Our Ref: Y/74/21/DOC

Approval of details reserved by condition imposed under ref Y/146/20/RES relating to Condition Nos 3 - in-curtilage storage spaces for houses & maisonettes, 4 - elevation & floor plan details of the proposed detached garages and 7 - external lighting.

Land at Street Buildings North End Road Yapton BN18 0DT

Job No. A 856	Drg No. 072	Rev. B
-------------------------	-----------------------	------------------

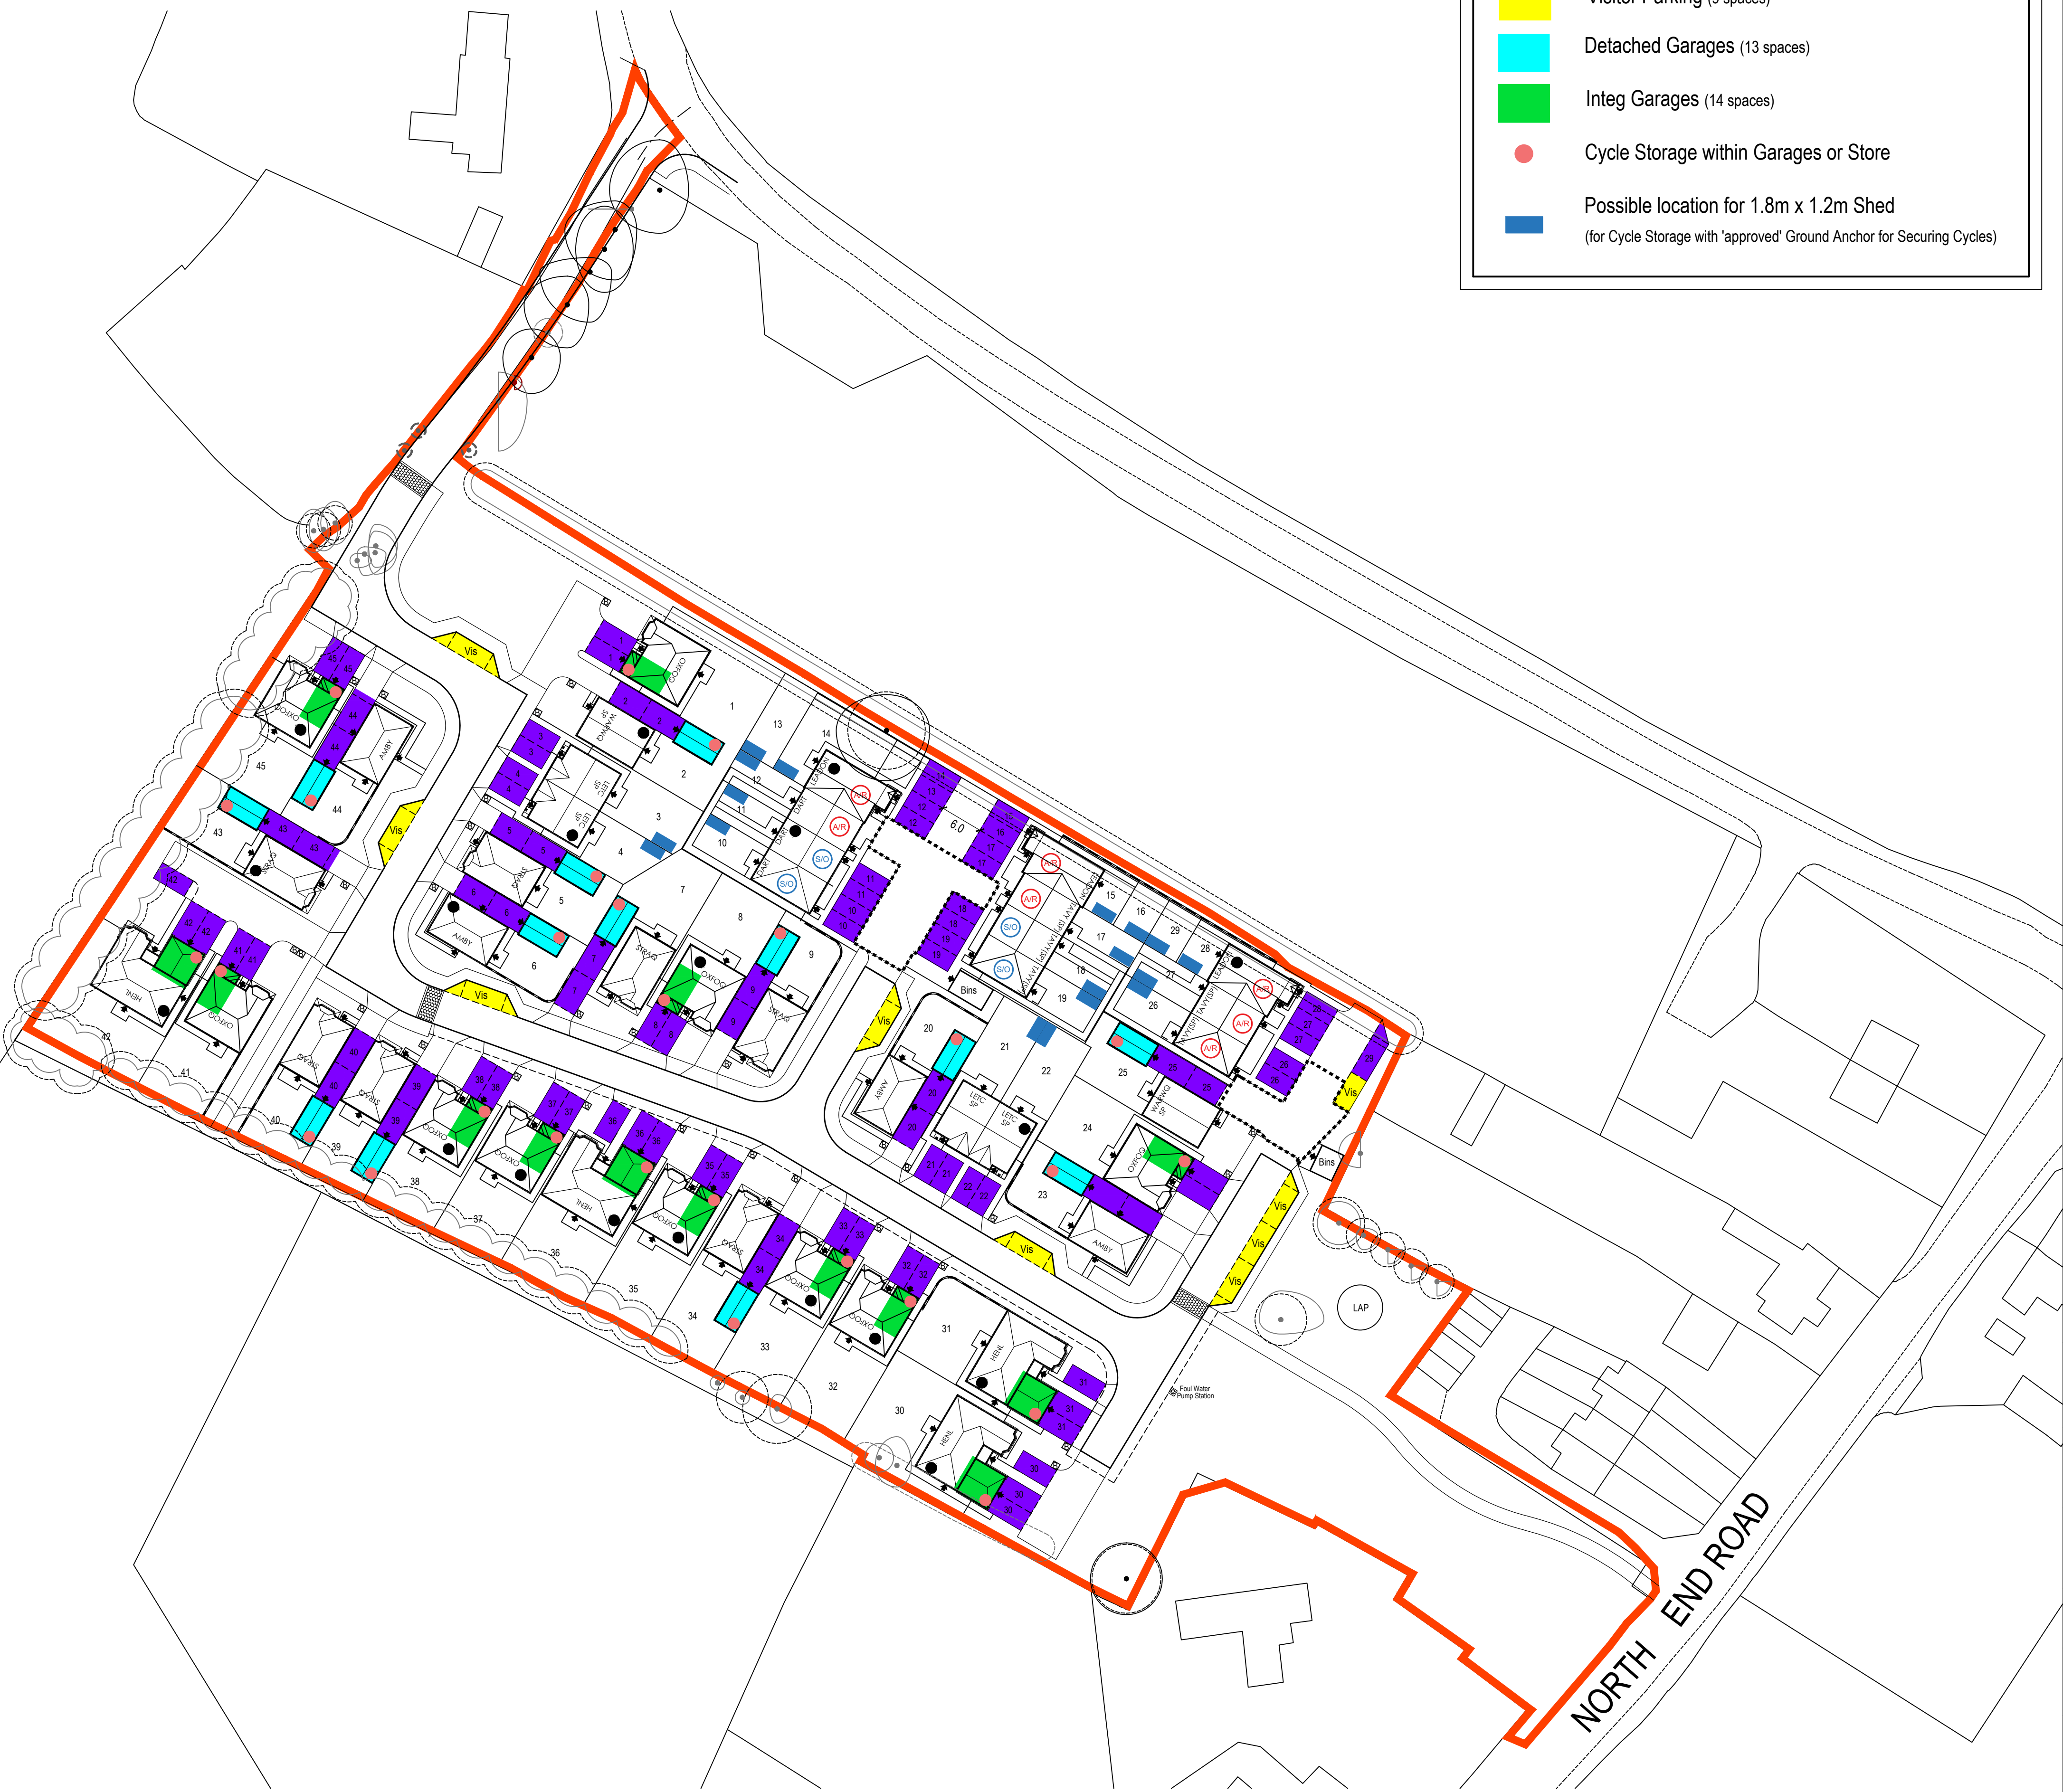
Arun District Council have decided to **REFUSE details reserved by condition for the following reasons:**
Drawing "Parking & Cycle Storage Plan" (Dwg No 072 Rev B) show the provision of cycle storage for each dwelling plot and are considered by WSCC highways to be appropriate.

However, no details are provided of the proposed stores/sheds (in which cycle storage will be accommodated) for plots 2 & 4, 10-19, 21 & 22 and 26-29.

The condition is therefore not discharged and you will need to provide a revised submission which

includes the elevations of the stores/sheds.
